COLORADO
Department of Transportation
Region 2
Traffic & Safety - Access Permits

RE: PPR-2424 Foley's Public House Interior Remodel

The submittals for Foley's Public House Interior Remodel (No Expansion) received July 8, 2024 have been reviewed by CDOT Access Management. CDOT Access Permits for the accesses were issued in August of 2020 and expired in 2021. Our comments follow:

ARCHITECTURAL SITE PLAN

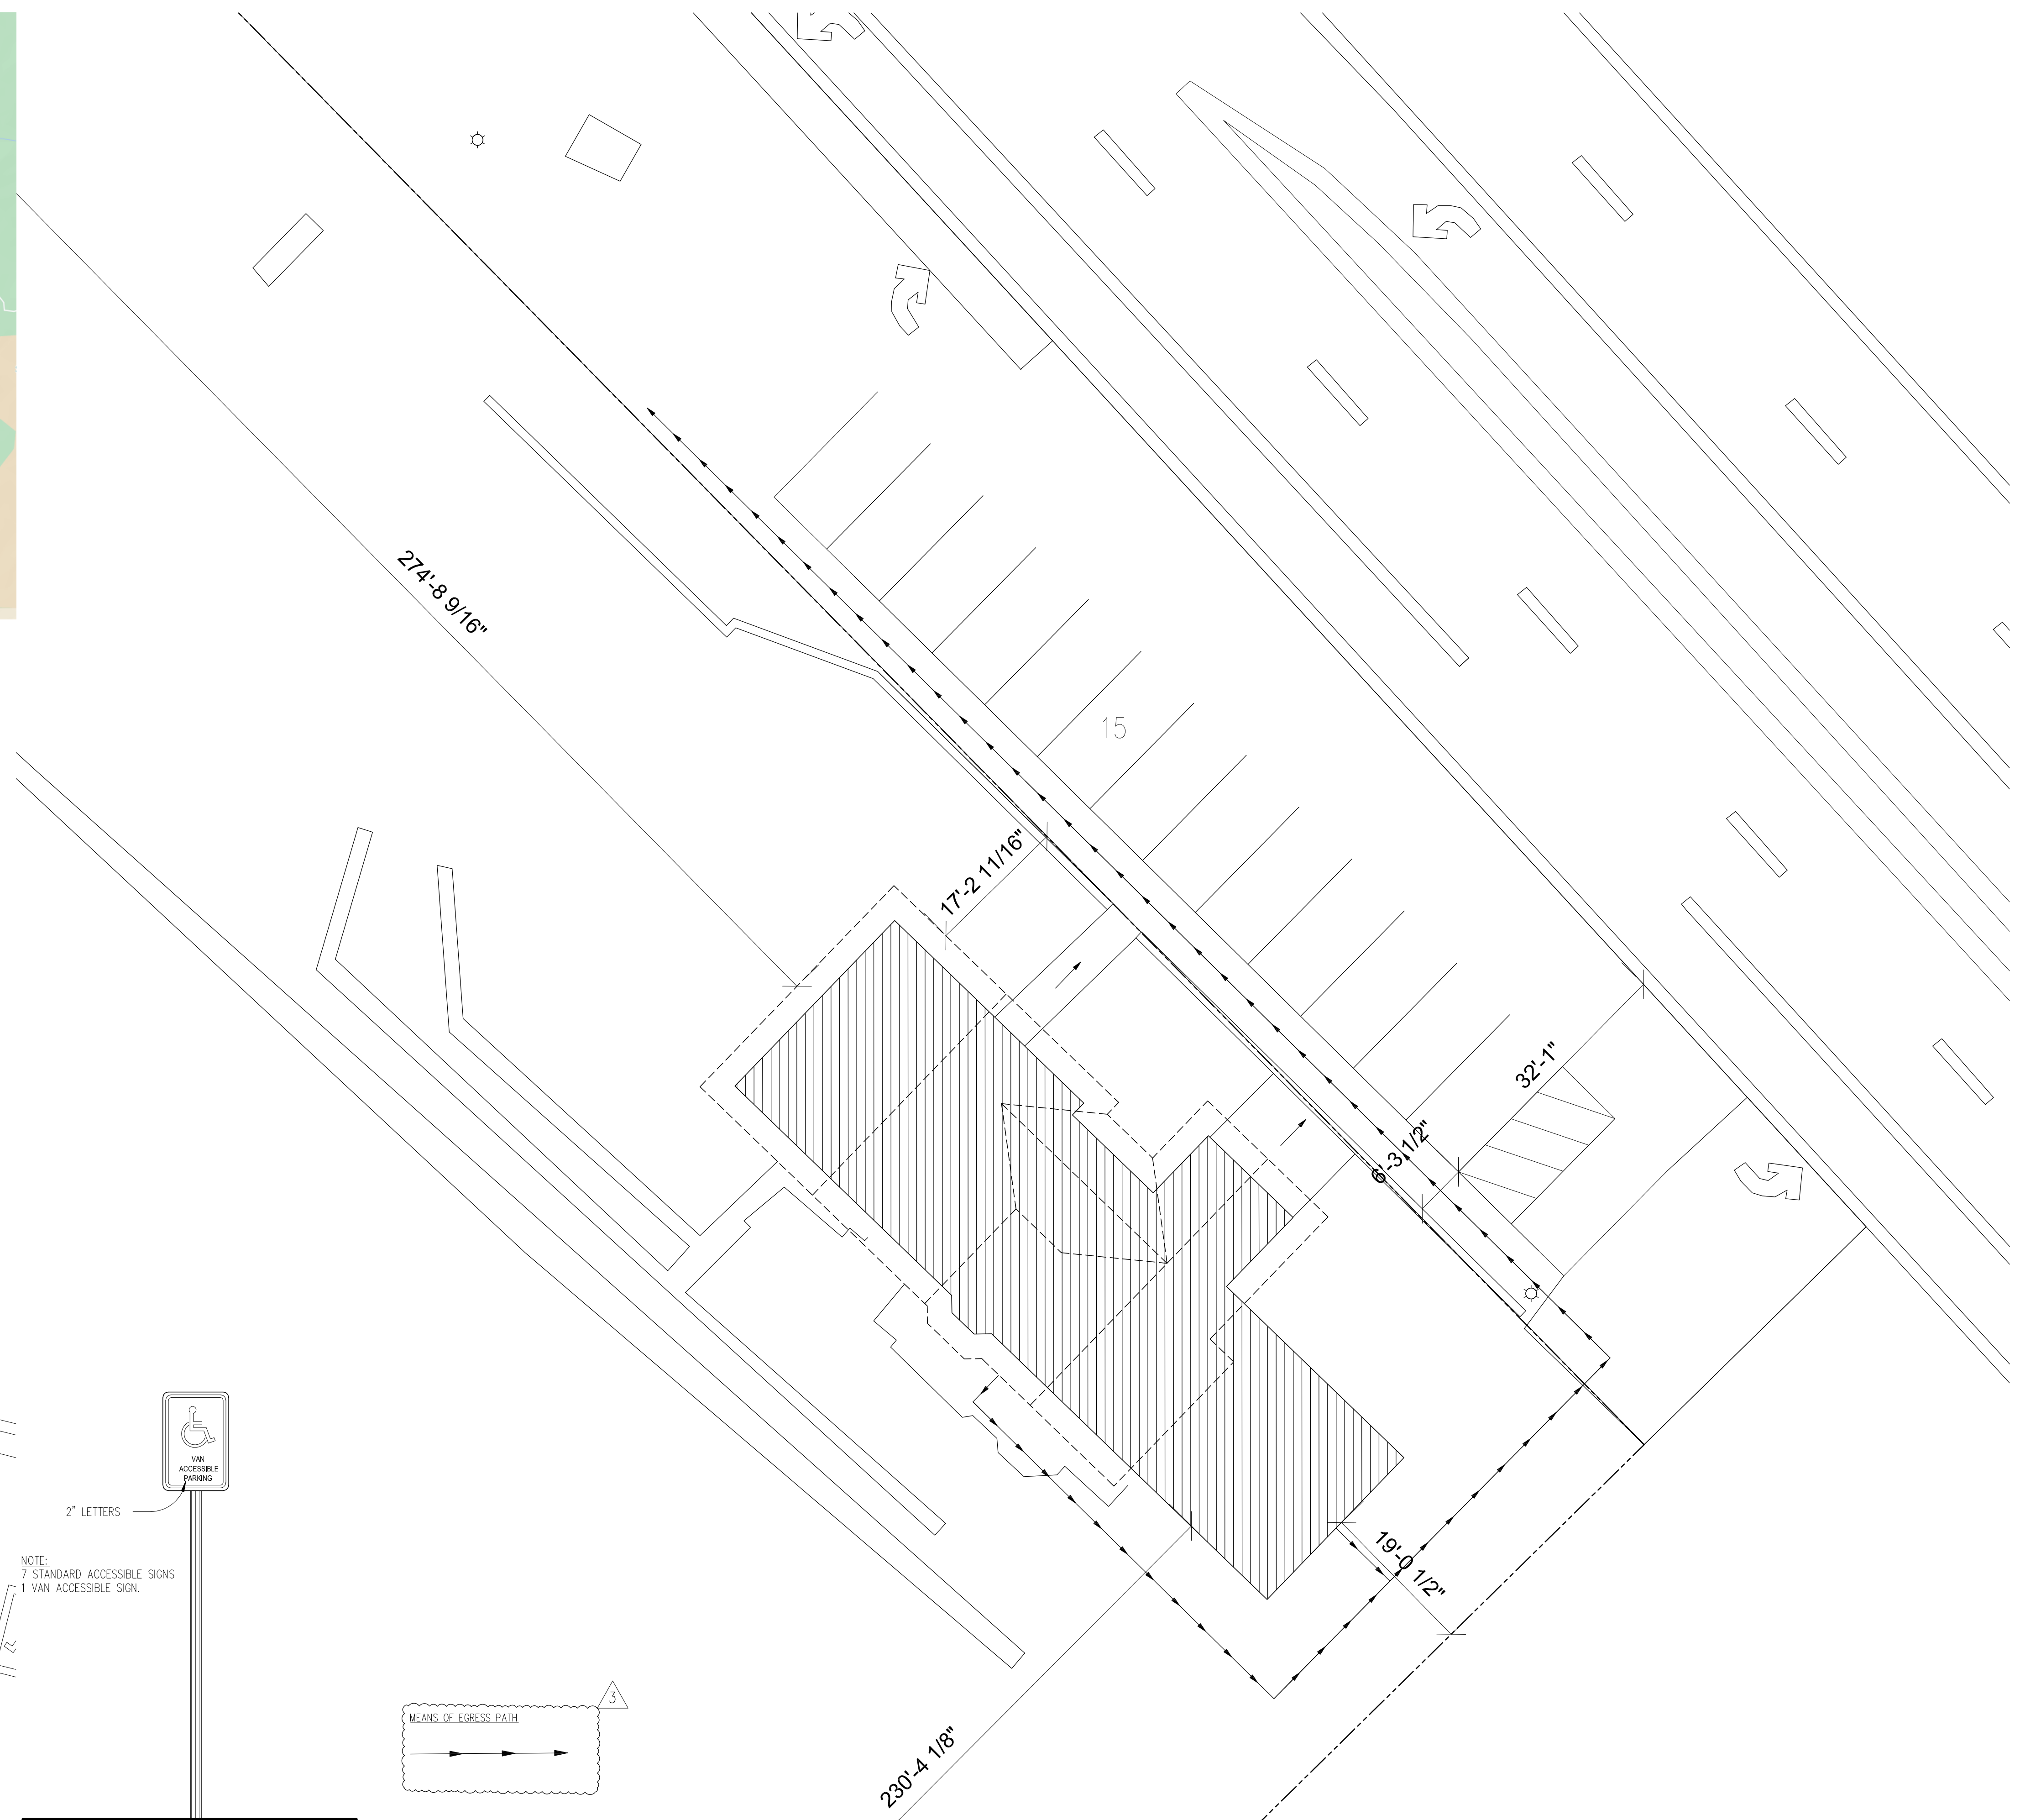
- **Access Permits are required to document the existing undocumented access locations to avoid closure of the accesses.**
- A CDOT project completed the improvements that Mr. Foley was required to make with the permits.
